# CITY OF ALBUQUERQUE

March 9, 2016

**Re: Marble Brewery**  
**9904 Montgomery Blvd., NE**  
**Traffic Circulation Layout**  
Engineer's/Architect's Stamp **NO STAMP** (G21-D043)

TRAFFIC CIRCULATION LAYOUT

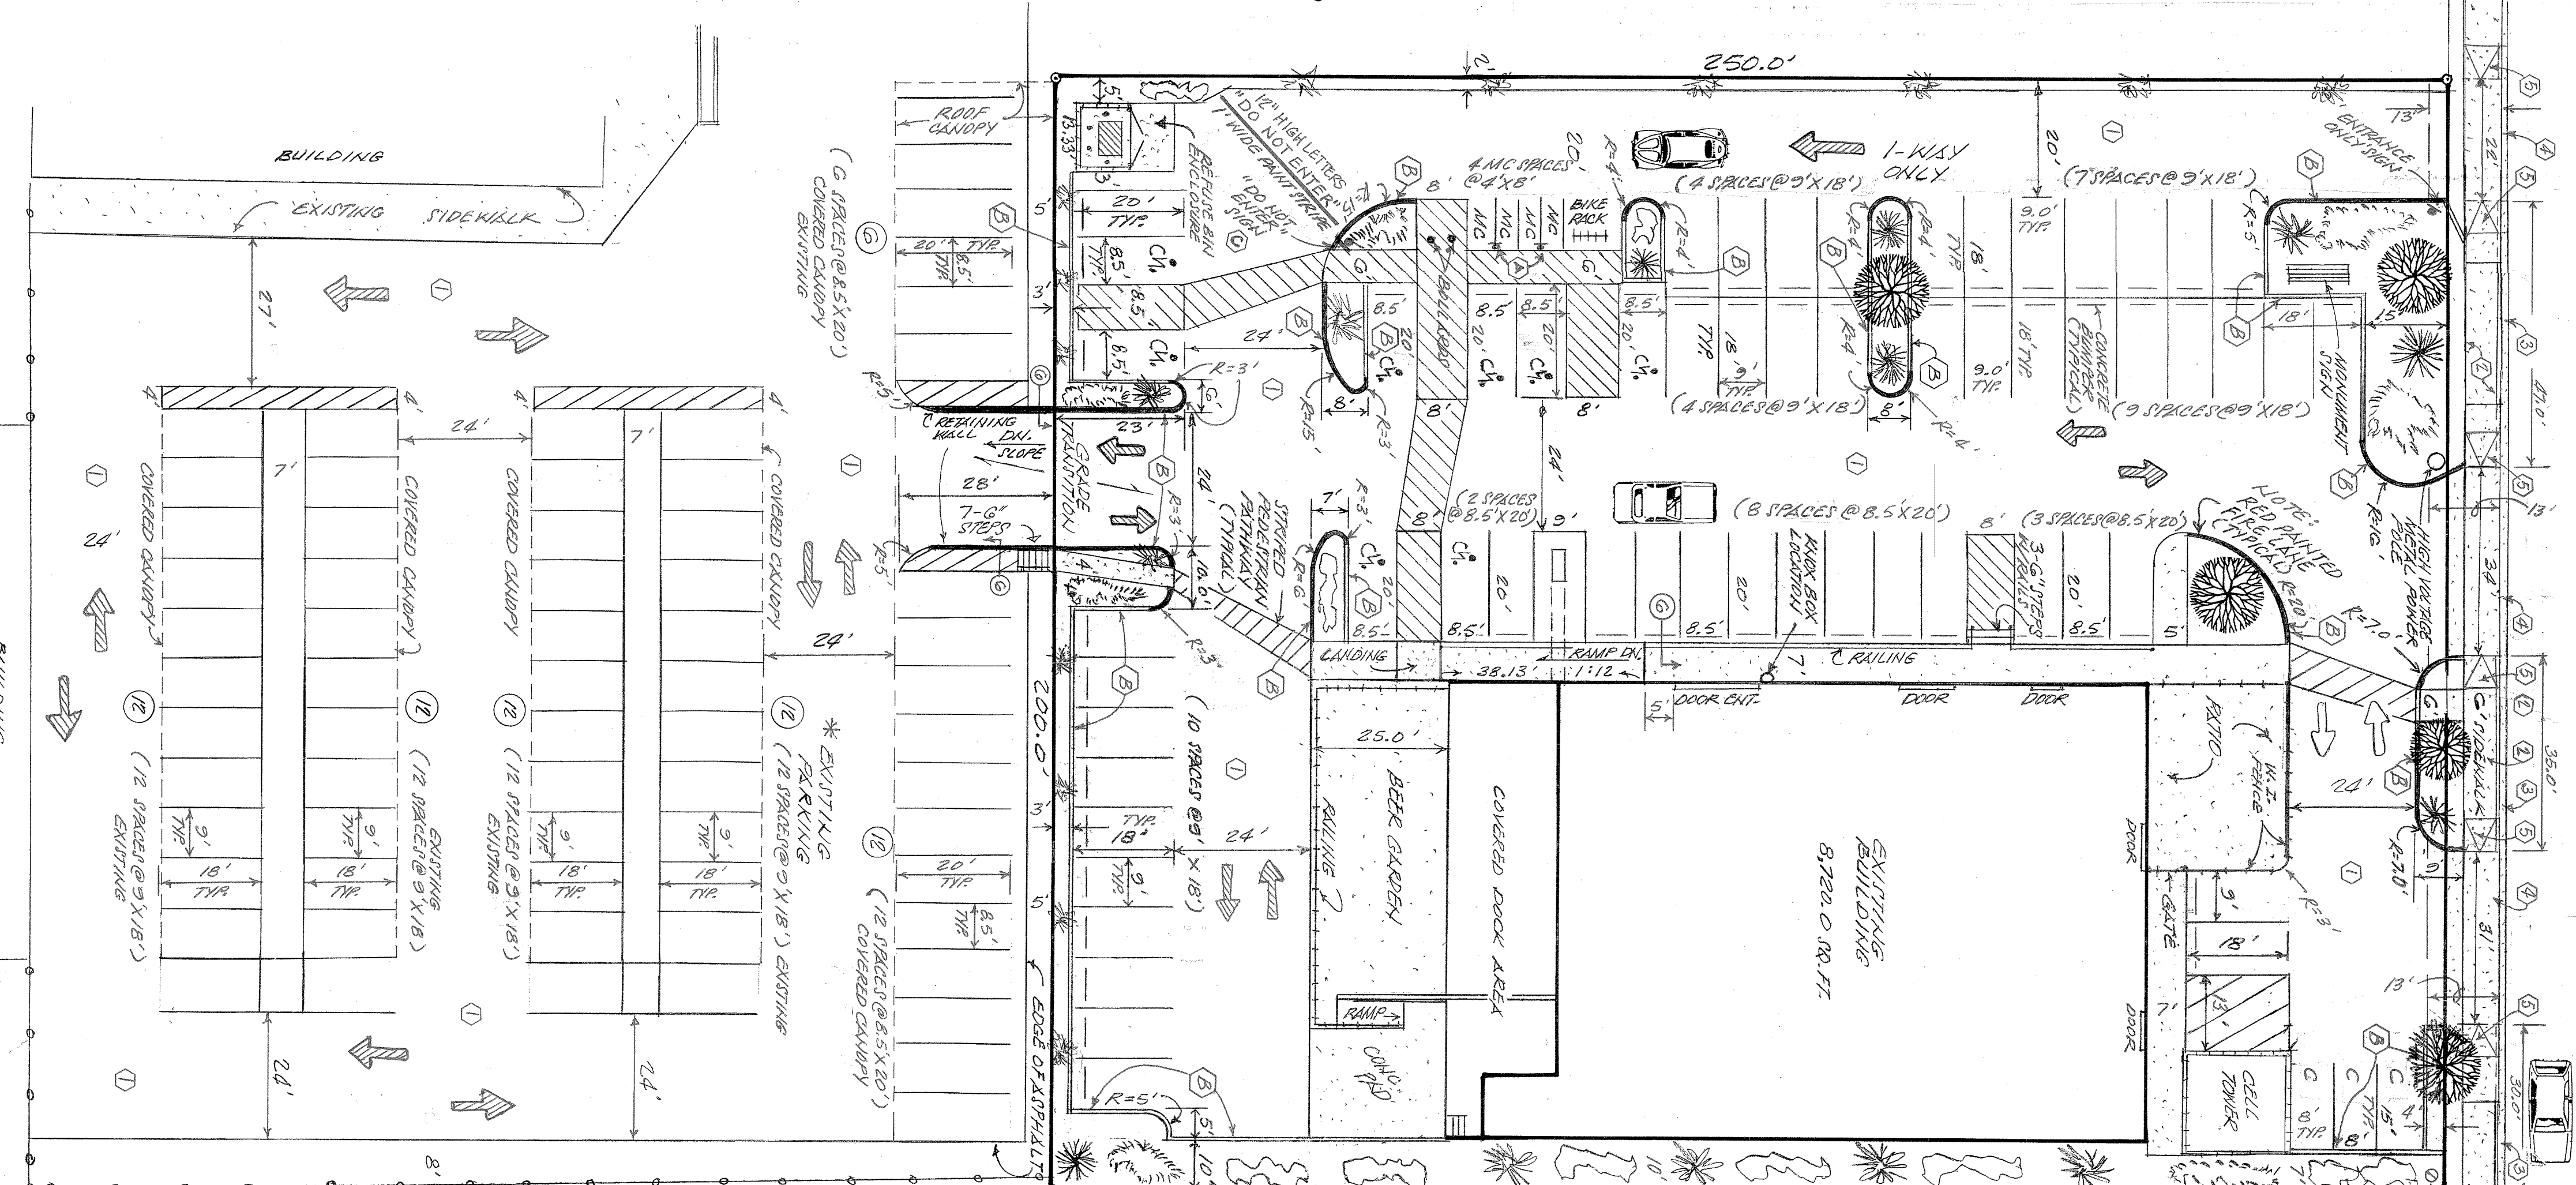
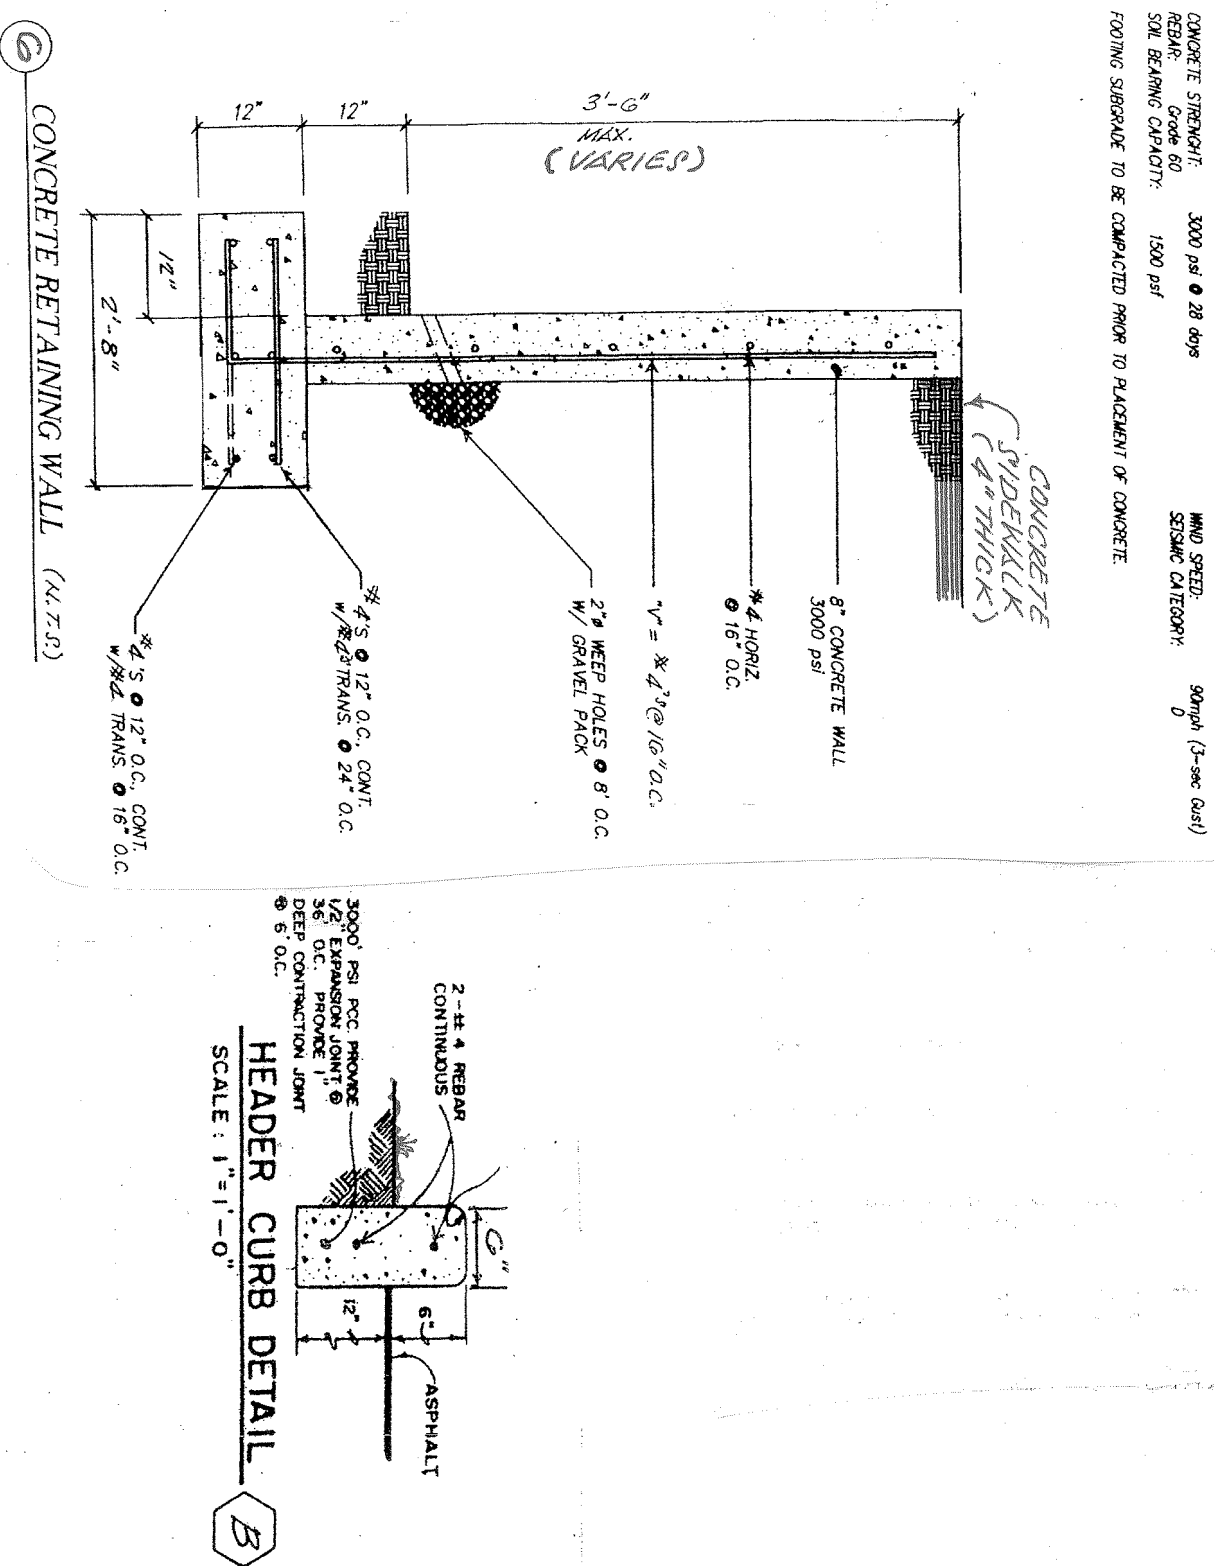
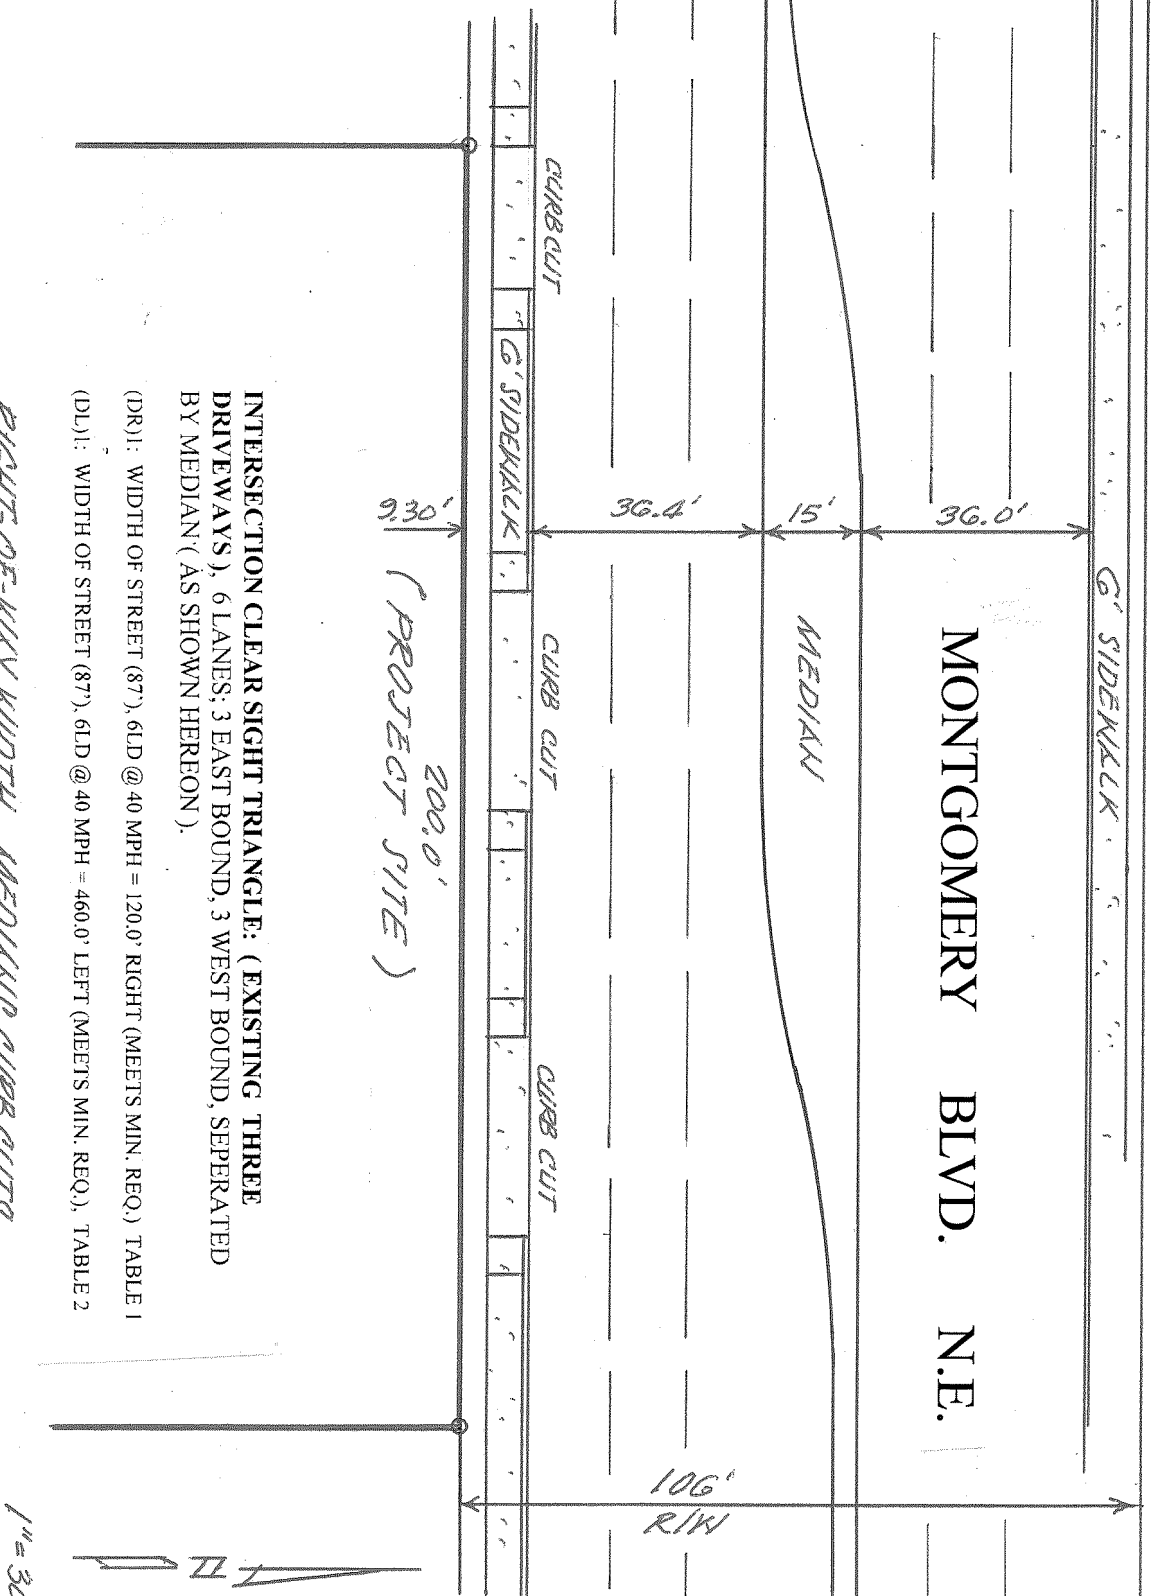
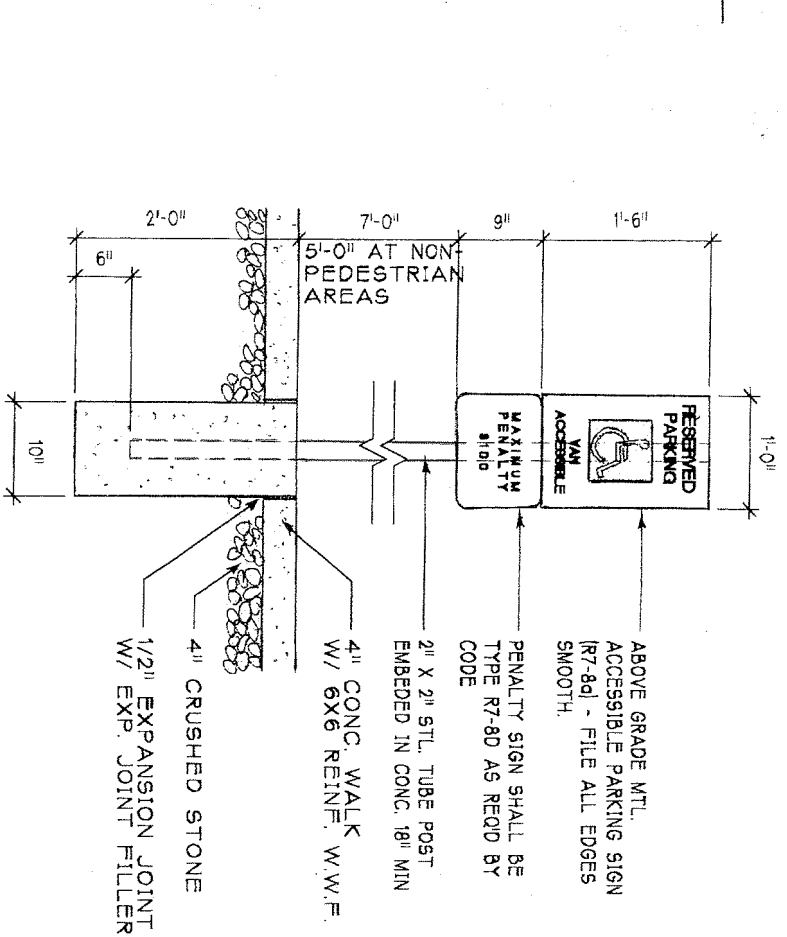
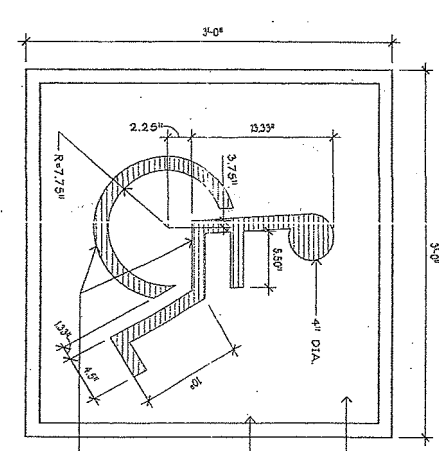
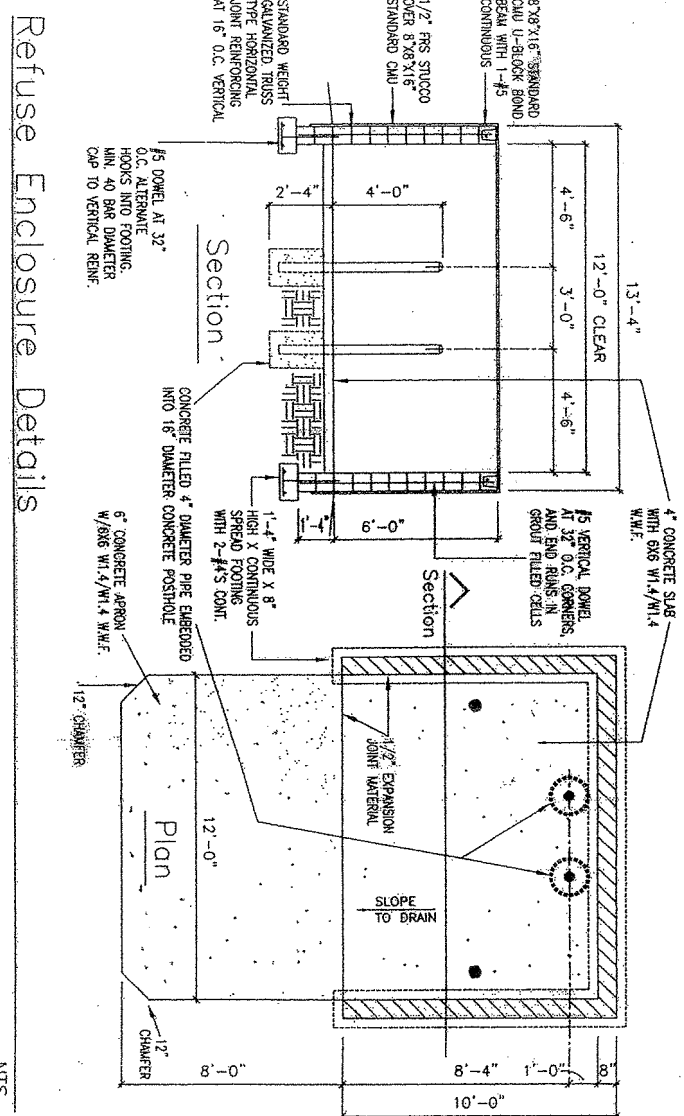
1. The traffic circulation layout must be stamped, signed, and dated by an engineer or architect licensed in the state of New Mexico.
2. Please identify location of Fire Department connection. If located on side of building, an access isle must be provided and no parking allowed in front of connection site.

3. Identify all existing access easements and rights of way with dimensions.
4. Identify the right of way width, medians, curb cuts, and street widths on Montgomery Blvd.

5. Please detail ADA ramp to building entrance, along with all building or patio entrances.
6. Please list the width and length for all existing and proposed parking spaces.

7. Label the compact parking spaces by placing the words "**COMPACT**" on the pavement of each space.
8. The ADA accessible parking sign must have the required language per 66-7-352.4C NMSA 1978 "**Violators Are Subject to a Fine and/or Towing.**" Please call out detail and location of HC signs.

9. The ADA access aisles shall have the words "**NO PARKING**" in capital letters, each of which shall be at least one foot high and at least two inches wide, placed at the rear of the parking space so as to be close to where an adjacent vehicle's rear tire would be placed. (66-1-4.1.B NMSA 1978)

10. Provide a min 6" or max 8" high concrete barrier curb or other acceptable barrier between landscaping and parking areas and/or drive aisles. Please call out detail and location of barrier curb.

11. Service vehicle and/or refuse vehicle maneuvering must be contained on-site; provide a copy of refuse approval.
12. One-way vehicular paths require pavement directional signage and a posted **"Do Not Enter"** sign at the point of egress. Please show detail and location of posted signs.

13. It is not apparent what type of pavement surface is being proposed. A hard driving surface will be required as part of this proposed project for parking area and drive aisles.

14. Please provide a sight distance exhibit (see the *Development Process Manual, Chapter 23, Section 3, Part D.5 Intersection Sight Distance*). Please show this detail for all entrances/exits on Montgomery Blvd.

15. Please add the following note to the clear sight triangle: "Landscaping and signage will not interfere with clear sight requirements. Therefore, signs, walls, trees, and shrubbery between 3 and 8 feet tall (as measured from the gutter pan) will not be acceptable in this area."

18. Unused curb cuts must be replaced with sidewalk and curb & gutter. A build note must be provided referring to the appropriate City Standard drawing.

19. All broken or cracked sidewalk must be replaced with sidewalk and curb & gutter. A build note must be provided referring to the appropriate City Standard drawing.
